Applicant: Mr Theo Fordham

Proposal: Installation of signage across two elevations including 3D illuminated sign (above the entrance door), a freestanding battery menu box and 3 no. window vinyl stickers

Address: Units 6 and 7 The Glass Works, Barnsley, S70 1GW

Proposed Elevations

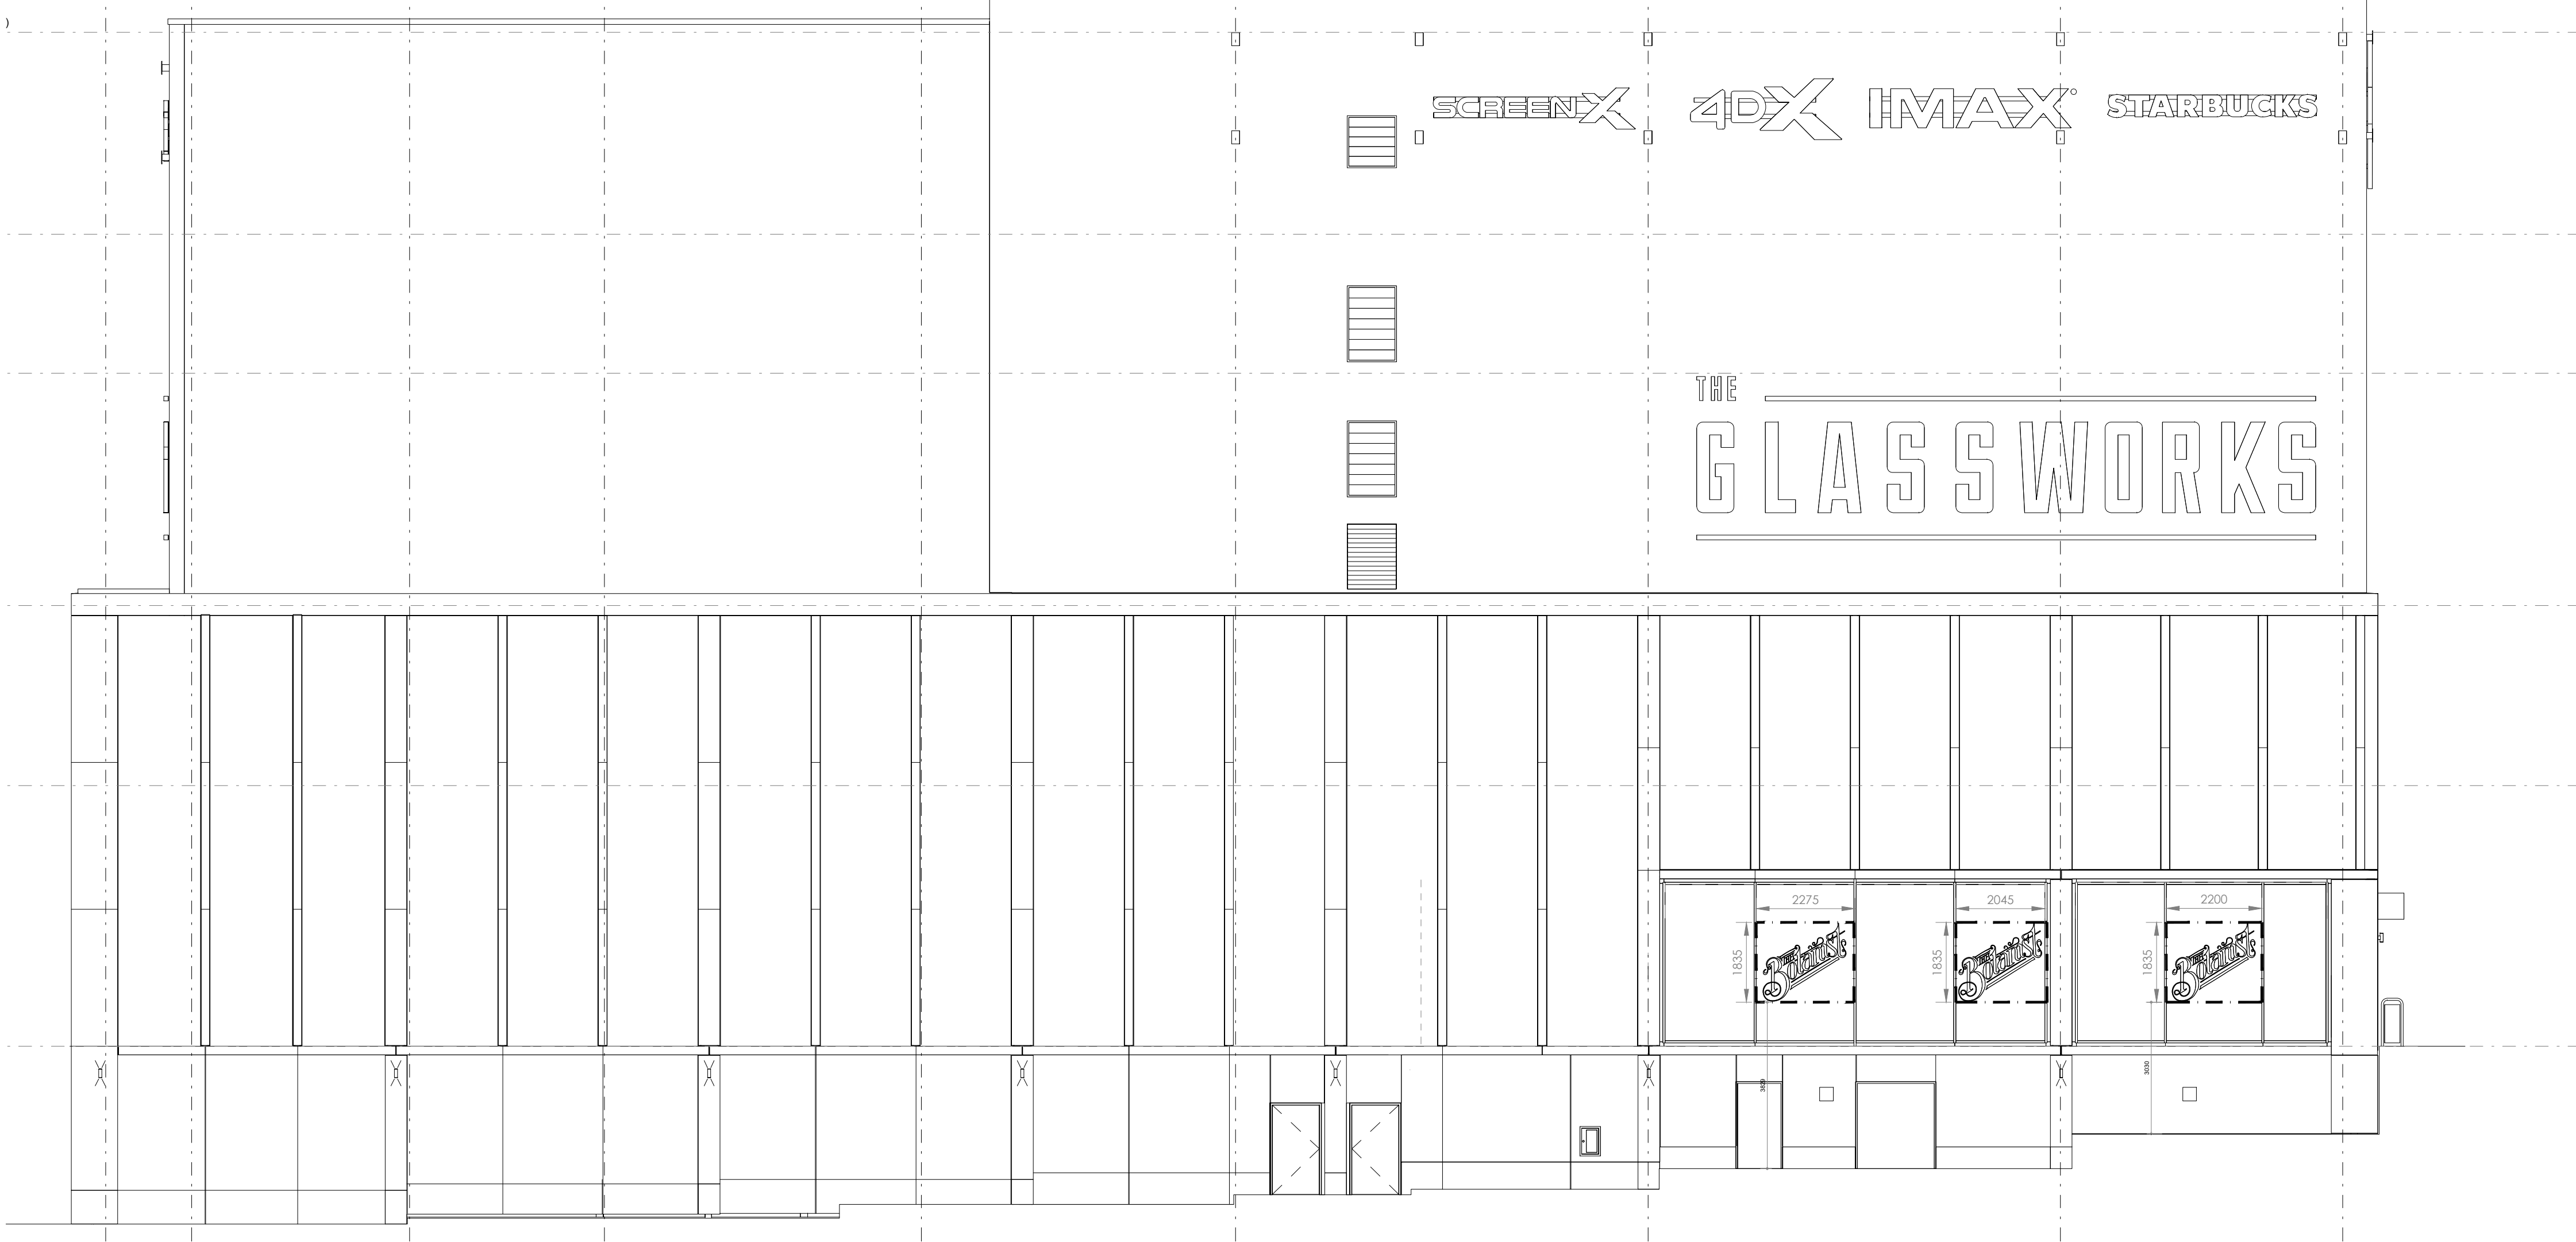
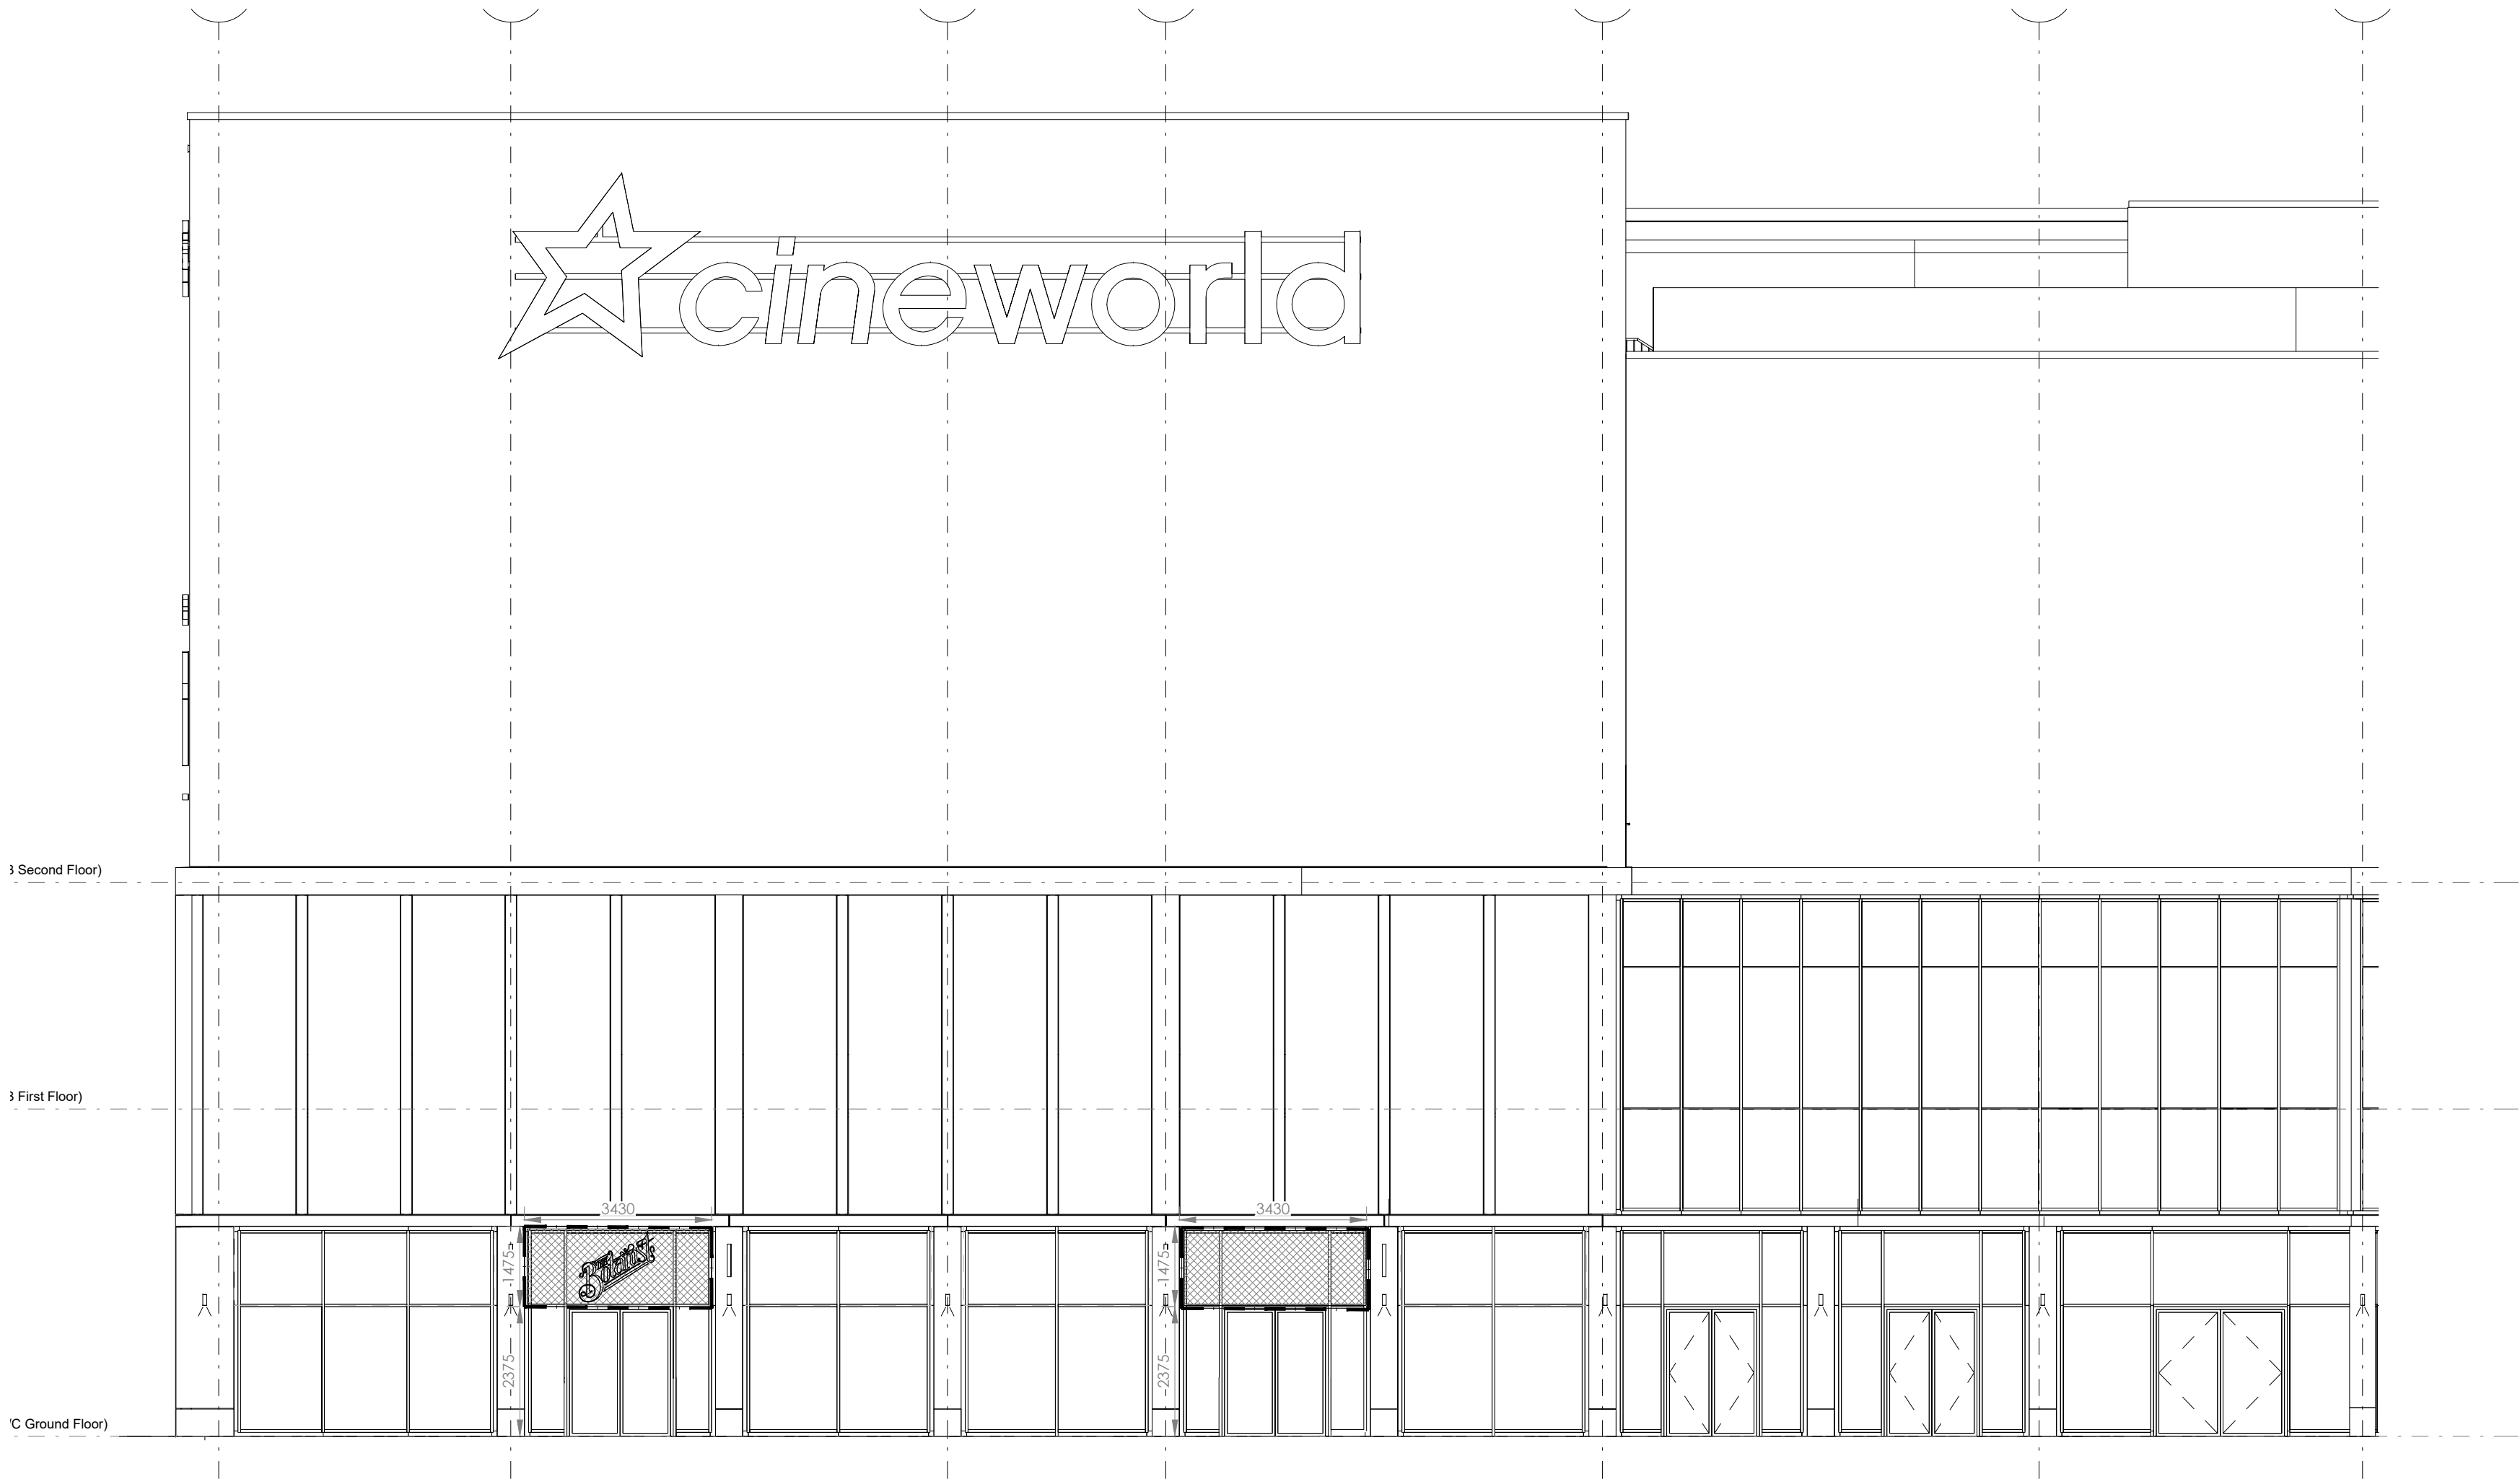
In response to amended plans: Further clarification is required to show the brown wire mesh that has been installed above the second set of doors facing the new town square and confirmation that it won't contain the wording 'The Botanist'. The mesh blends in well, doesn't appear as a solid board and is softened by the planting and structures in the foreground boarding the external seating area. The freestanding box menu is also on site, is low key in design and illumination and subject to it being brought into the bar during closing hours is acceptable. The three vinyls on the north elevation facing Interchange Square are accepted as an exception to the shop front design guide because they serve a function to direct pedestrians. Confirm no objections provided the plans are further amended to include the mesh over the second set of doors, as currently in place, and confirmation that lettering won't be added to that mesh.

The proposal is for 3 no Botanist logo vinyls on the North/side elevation, a 3D illuminated sign (200cd/m²) and freestanding battery menu box and additional mesh screen on the west/front elevation. The application drawings have been amended to reflect the signage as displayed and clarification has been provided that Botanist' wording will not be added to the additional mesh screen on the west/front elevation.
